Revised 12/5/2022 - 3rd Review

RE: Vue De La Parc Apartments – Development Plan and Nonuse Variance – 3RD Review Comments

FILE: Application No. DEPN-22-0222

GENREAL INFORMATION

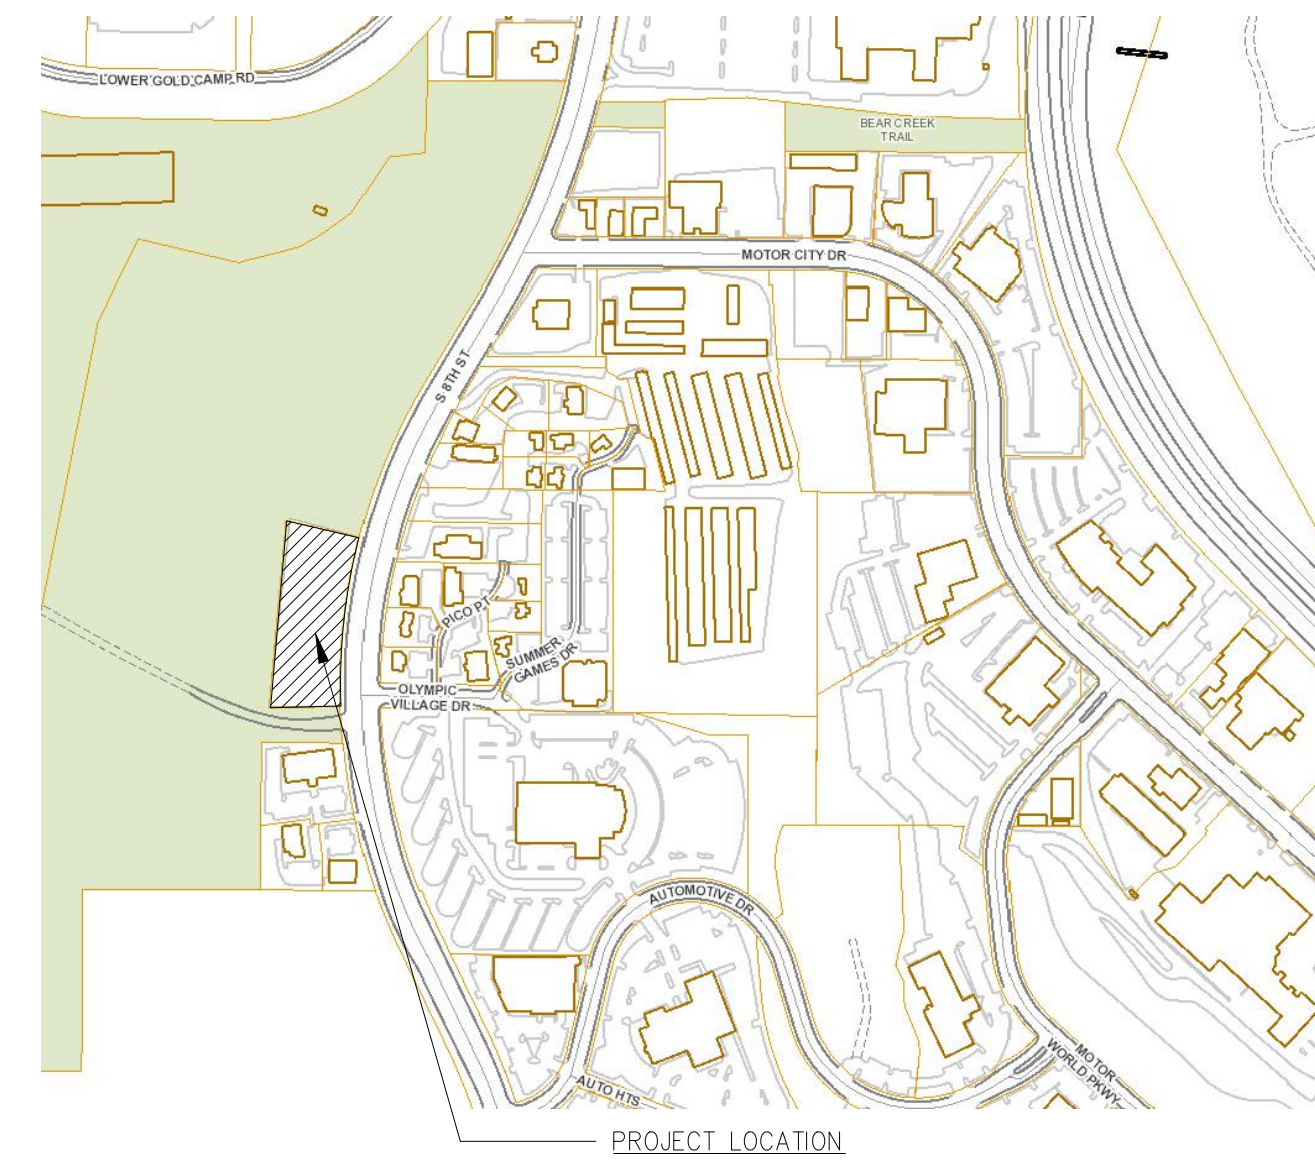
FIRM panel number should read 08041C0729G. **Panel Number updated**

Include the flood zone in the Floodplain Note on the cover sheet (e.g. Zone X). **Zone Added**

Please show and label major drainageways in the vicinity map. **Bear Creek Drainageway Noted**

Include a scale for the vicinity map. **NTS, graphic scale added**

Title the Development Plan as shown on the Plat. **Title edited**

VUE DE LA PARC
DEVELOPMENT PLAN
PRELIMINARY GRADING

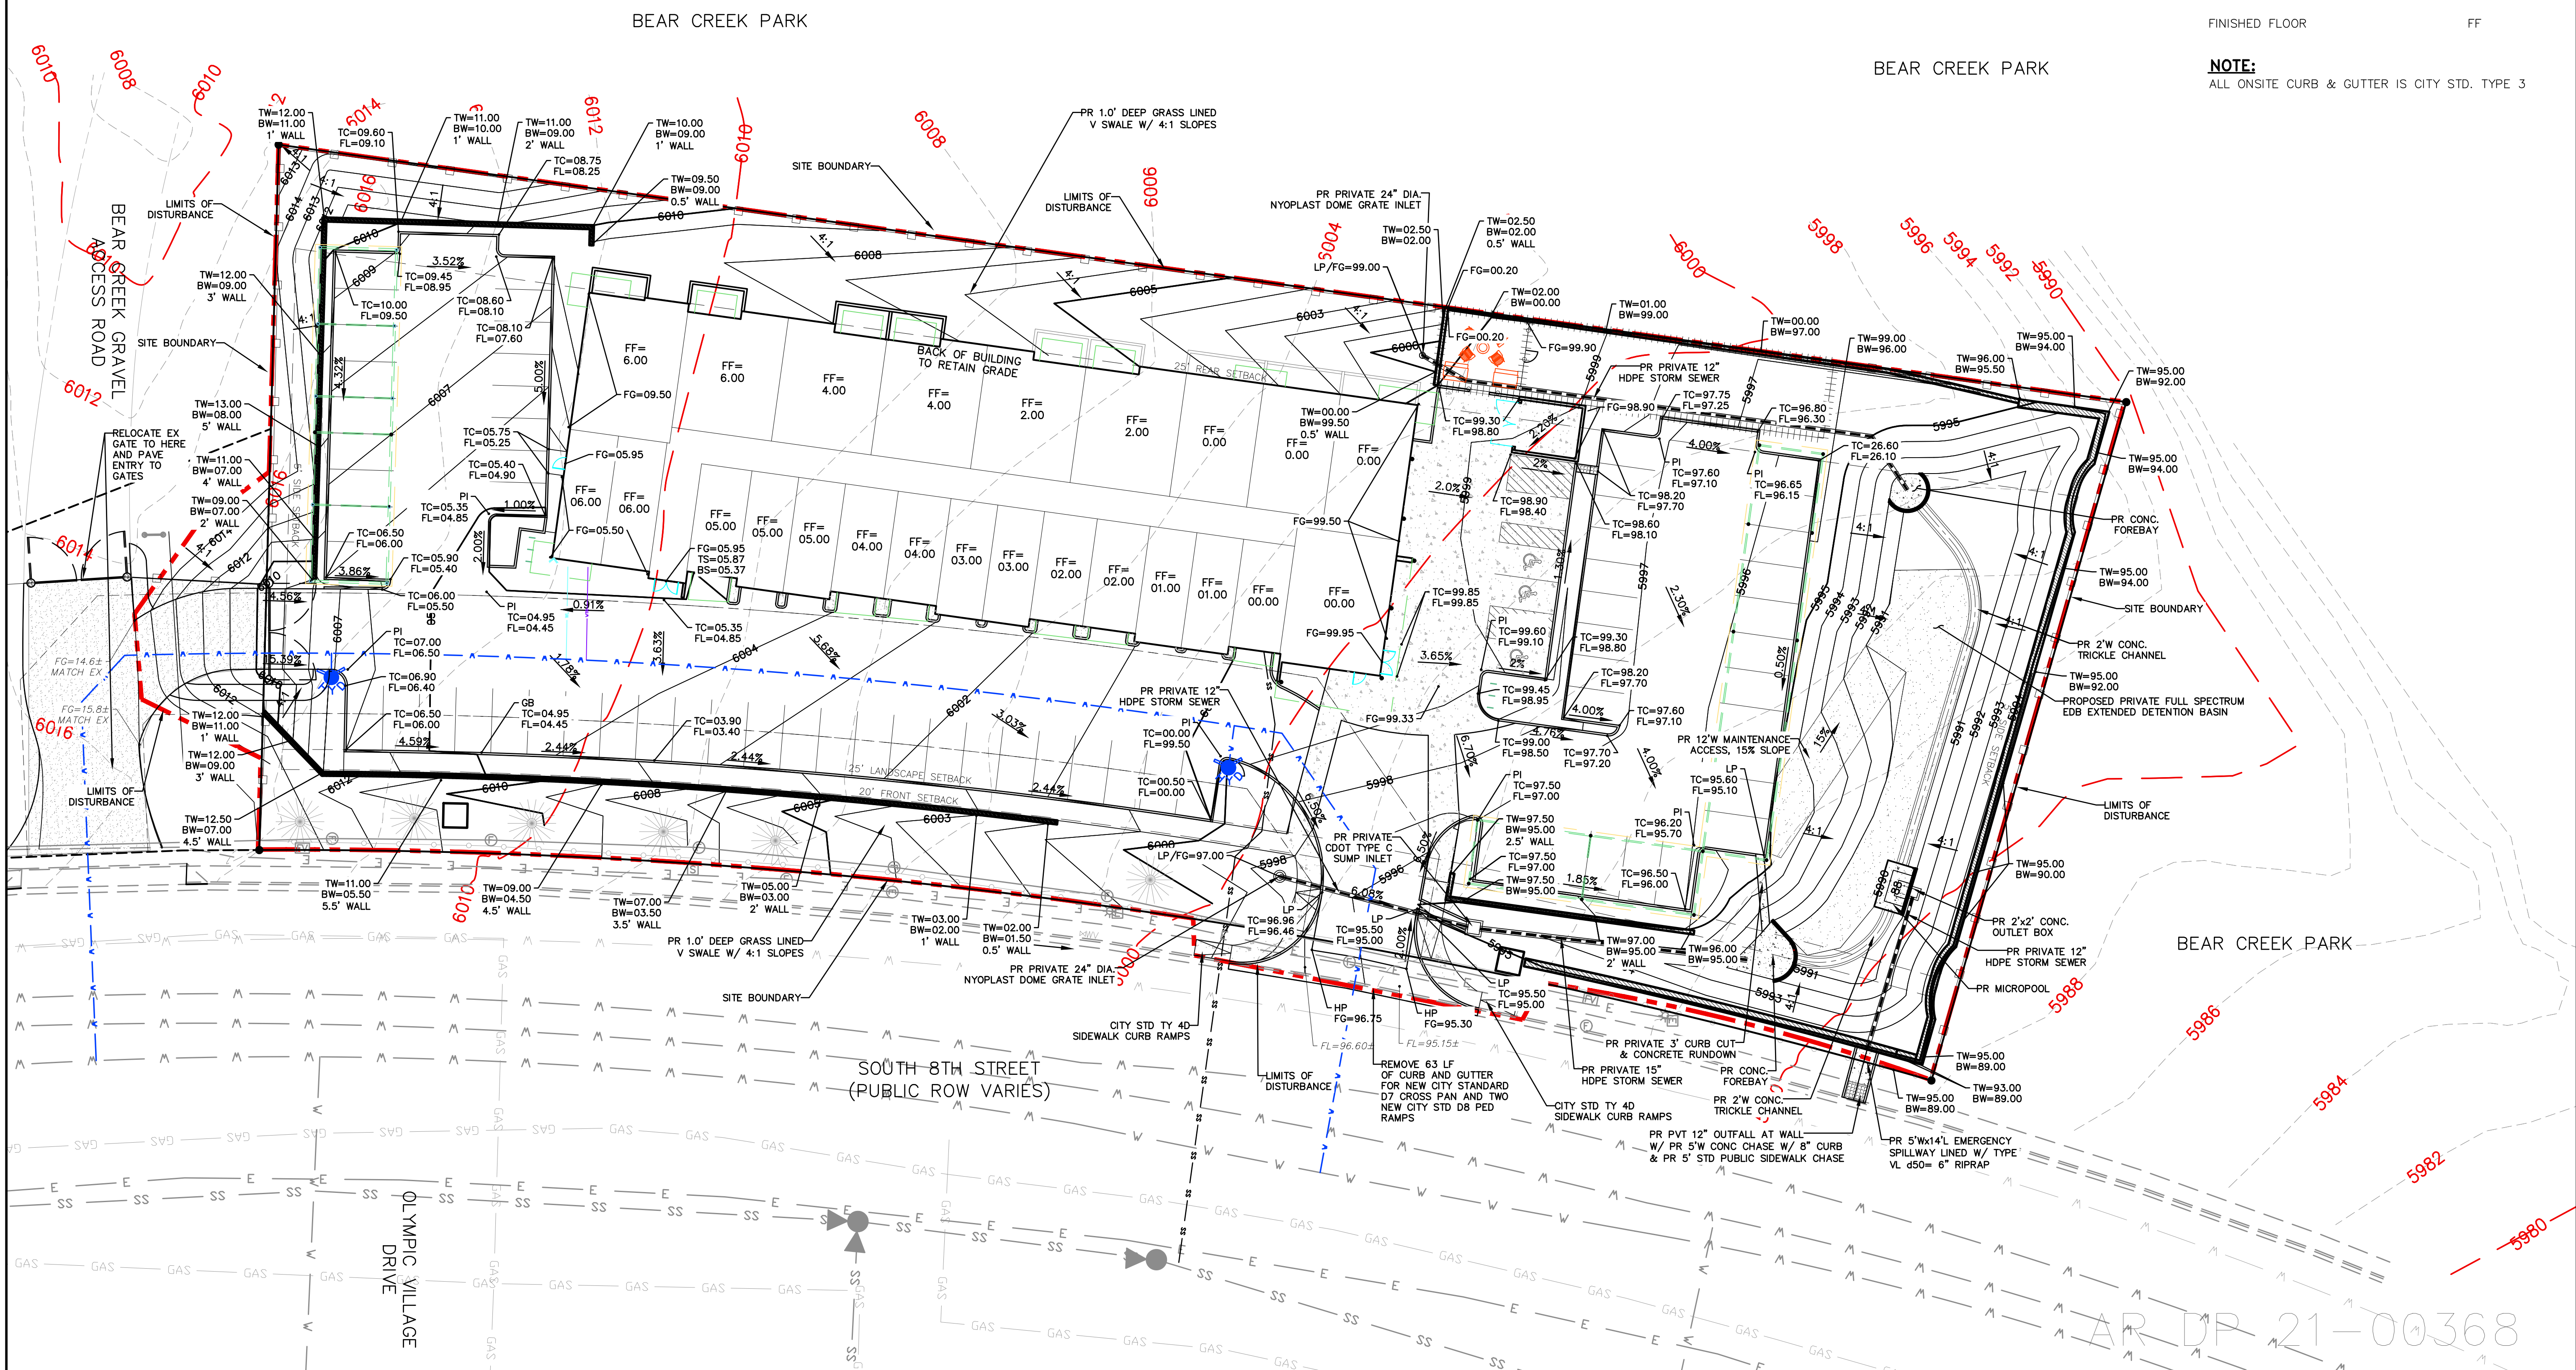
This is labeled as a grass lined swale on the Grading Plans, but these plans show rock. Please clarify. **Revised as Rock**

FINAL LANDSCAPE PLAN

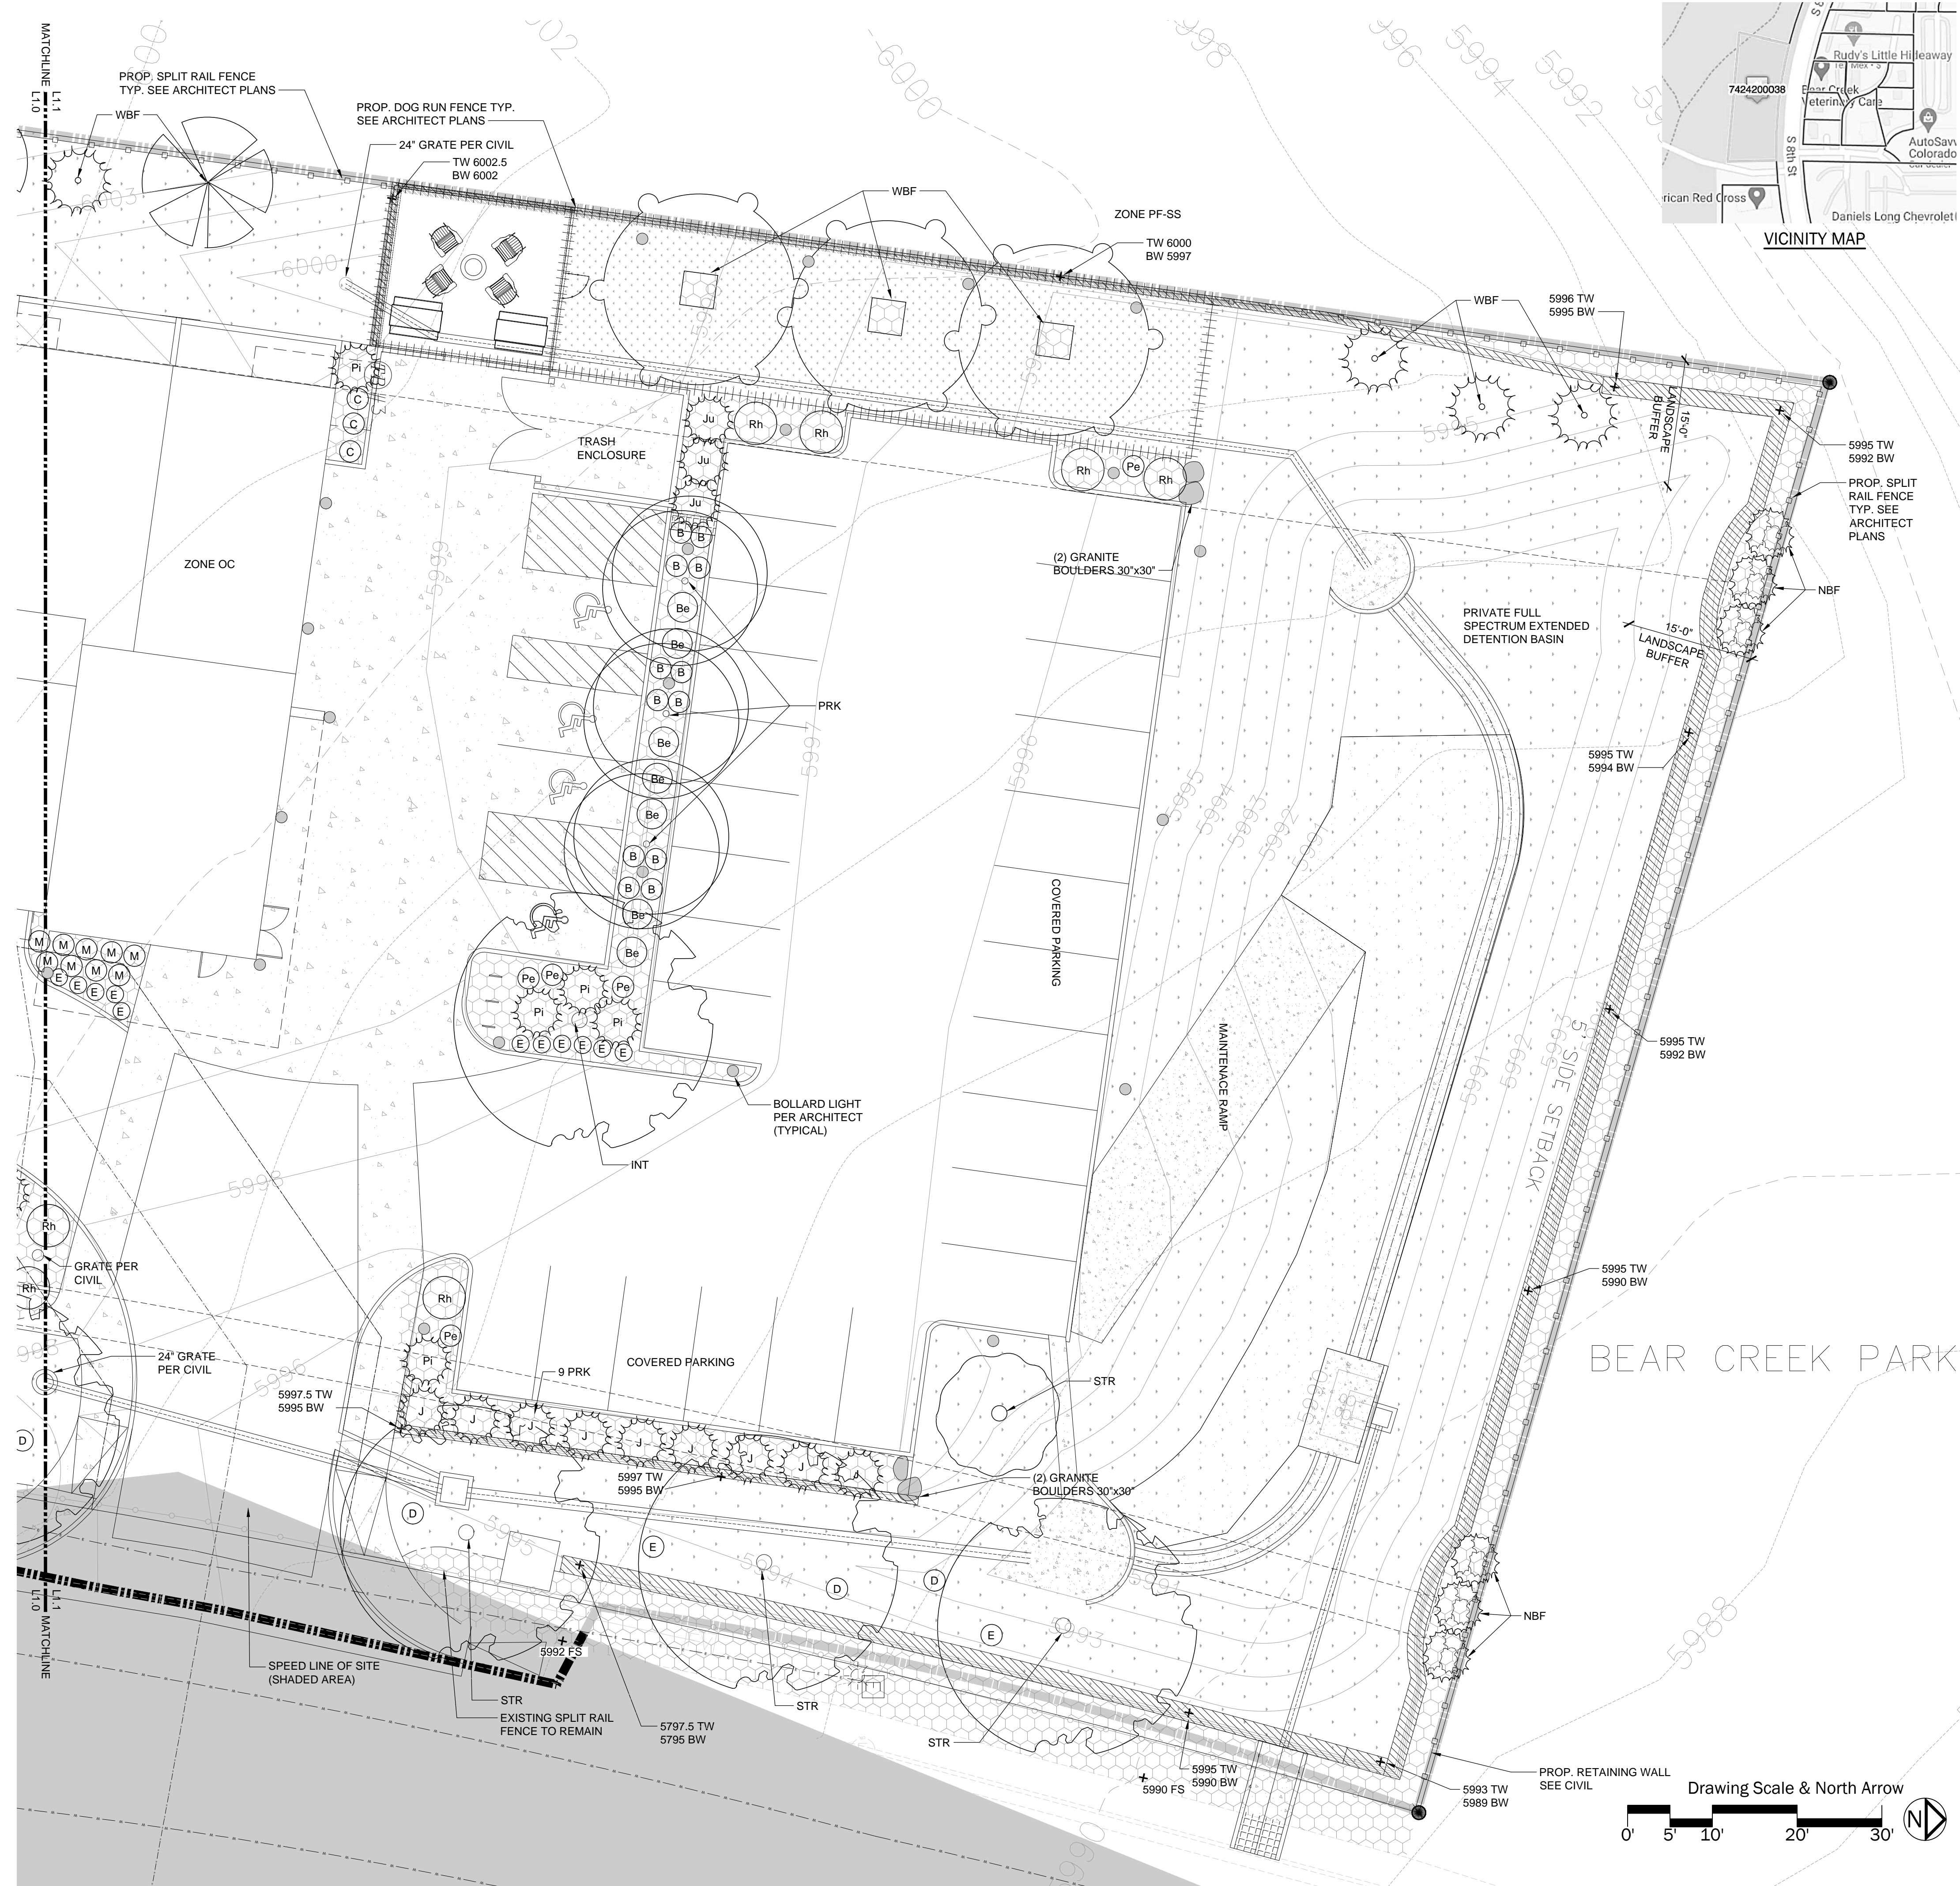
Update sheets 6 thru 8 to read "Final Landscape Plan and Details" **Revised**

add the following after the zoning "Bear Creak Park" **Revised**

If any site trash enclosures are planned, show and label on the plans and provide landscaping (fastigated form) screening around the sides of the proposed trash enclosure (where we have space - 7.4.323.C.5 and H and FLP Check list #30). **Trash enclosure is located to the north of the building and is screened**

Confirm the total amount of provided trees, staff is getting 65, revise the plans as needed. **Revised to 65**

Confirm the total amount of provided shrubs for the site, per the Site Calculation Charts, a total of 152 are needed but only 122 are provided. Revise the plans and plant schedule as needed. **160 needed and provided**
